OUT18/8311

**Bengalla Continuation Project Modification 4 (SSD 5170 MOD 4)
Request for comment on Response to Submissions**

Approved Development Layout

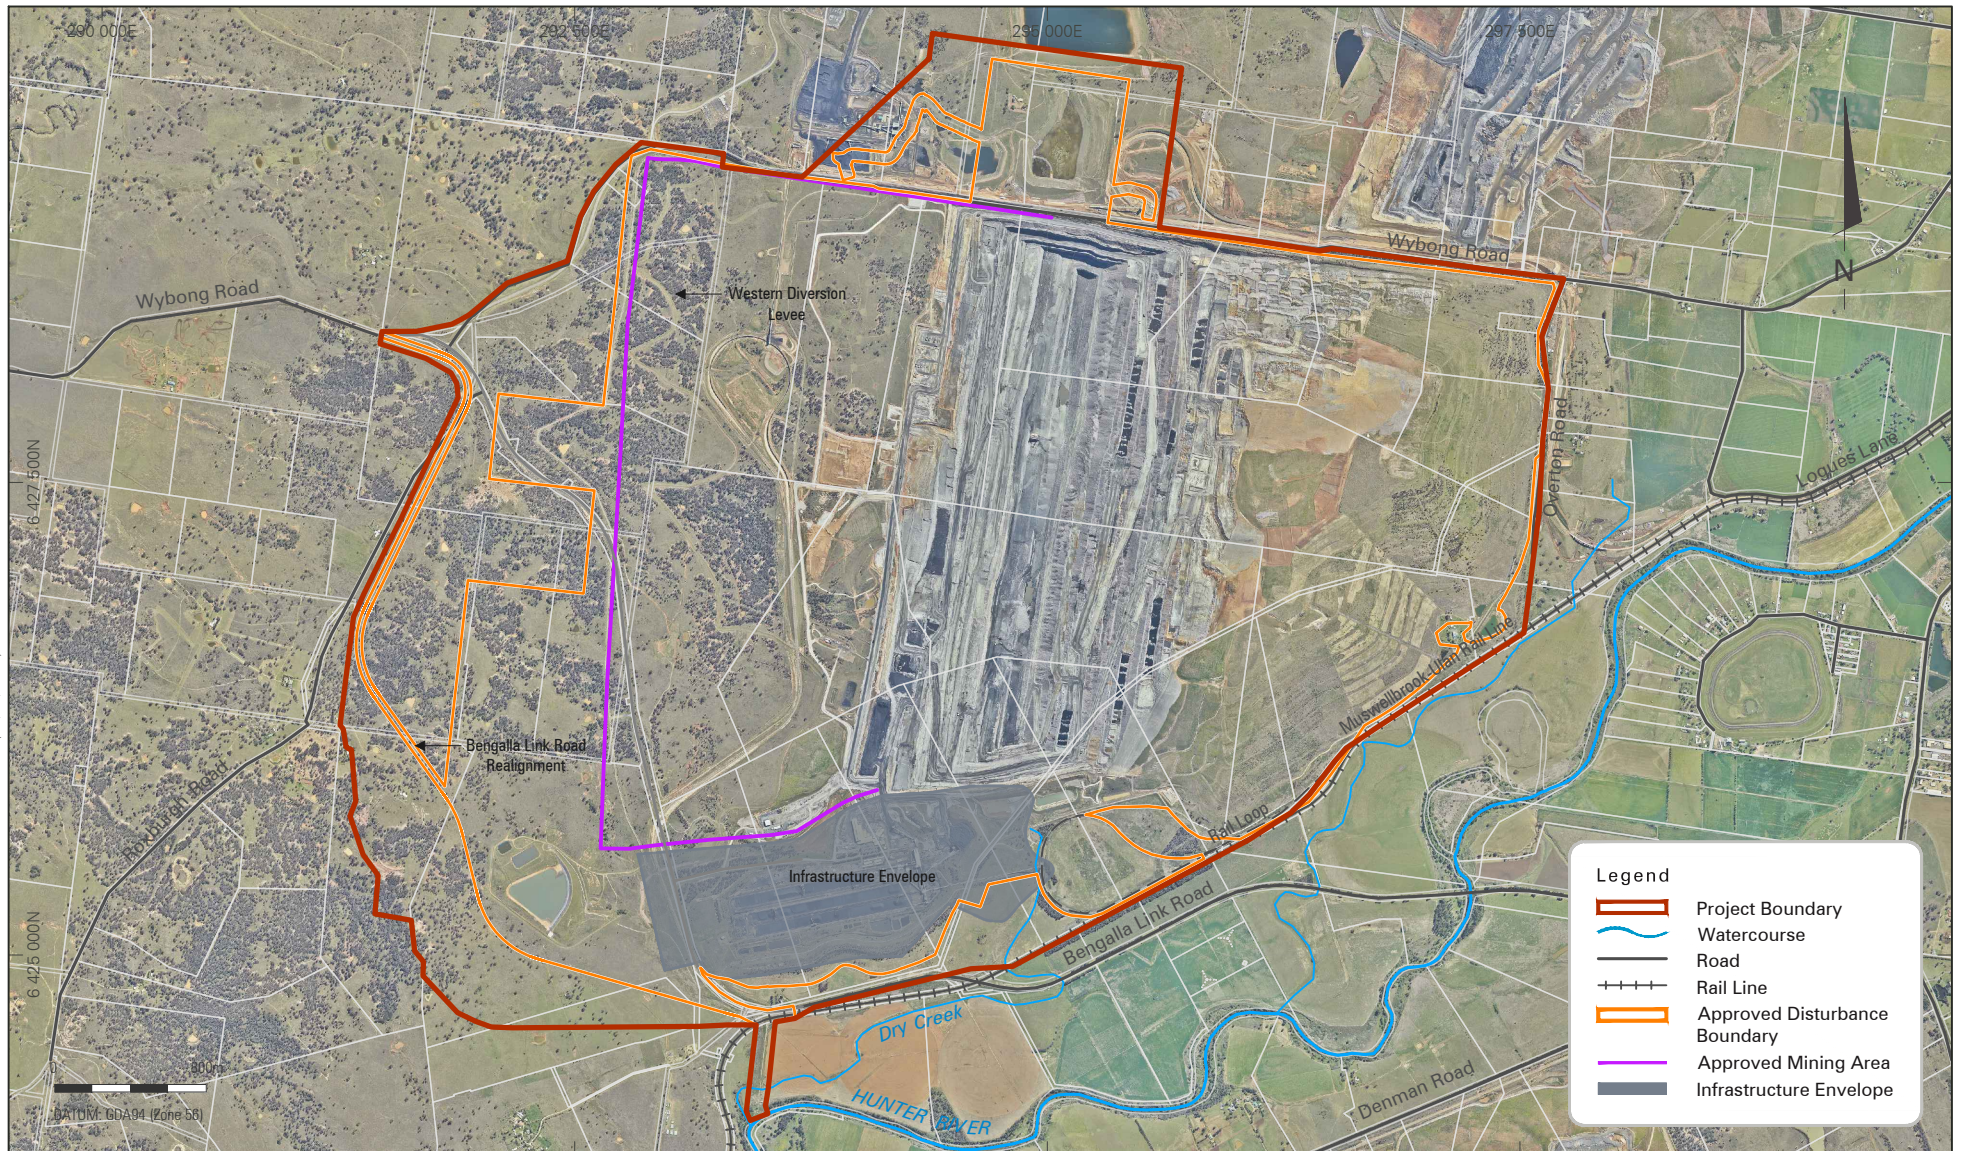
- 1 That the proponent be required to install a shallow alluvial monitoring bore down gradient of the new Dry Creek East Dam and include in the Water Management Plan.
- 2 That the proponent be required to update the Water Management Plan in consultation with DoI Water.
